Your Ref: OWPC18237
Our Ref: FG/52/18/PL
Please ask for:
Mrs A Gardner

Amendments to design approved under FG/95/16/PL, polytunnels, outdoor growing beds, tree nursery, storage & welfare facilities for a horticultural enterprise.
Quercus Nursery Littlehampton Road Ferring

Thank you for your internet comments made on 15th May 2018 which has been recorded as **'an objection'** with the comments as follows:

PROPOSED Polytunnel Plans

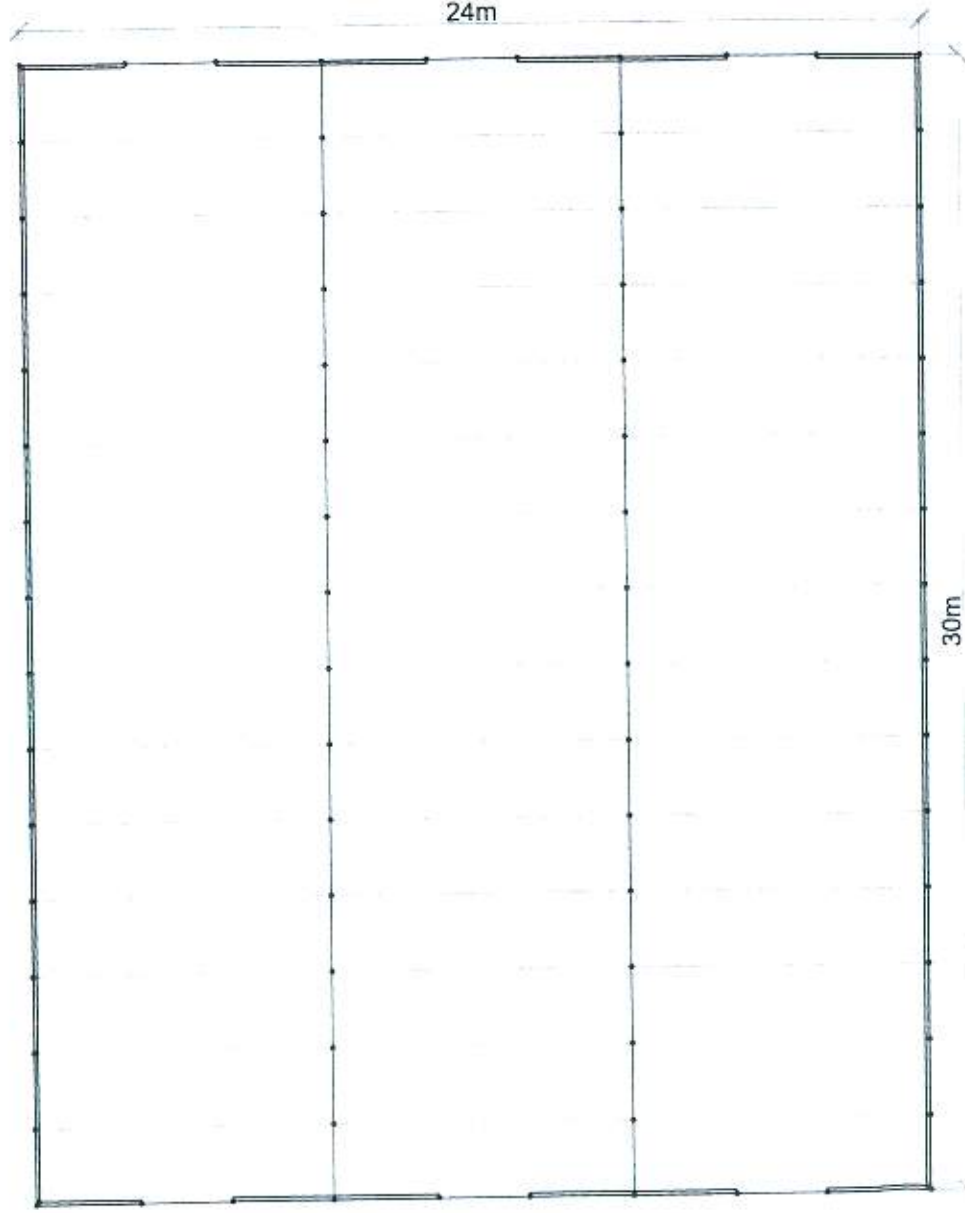
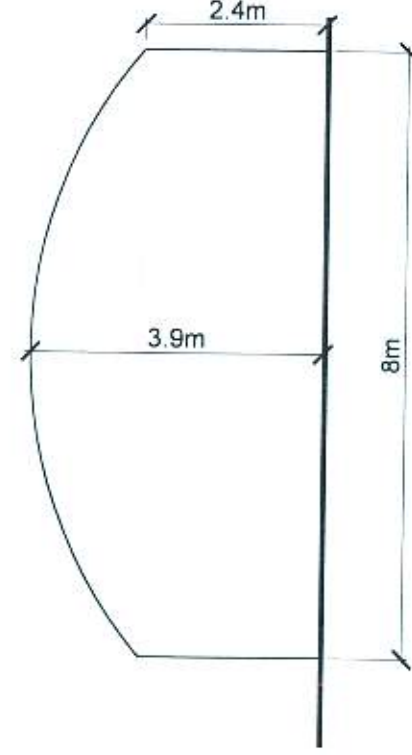
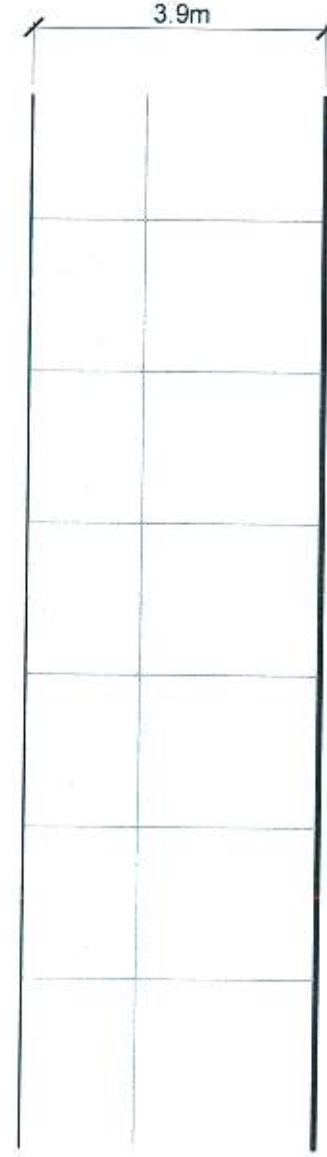
Whilst Ferring Parish Council recognises that this is agricultural land and sincerely supports local businesses of this nature in the designated location. We raise a concern and must object to the amendment of the polytunnels.

The proposed size of the polytunnels will fundamentally affect the landscape and impact on the surrounding area. At 3.9 metres in height, the proposed polytunnels will alter the visual impact of the site.
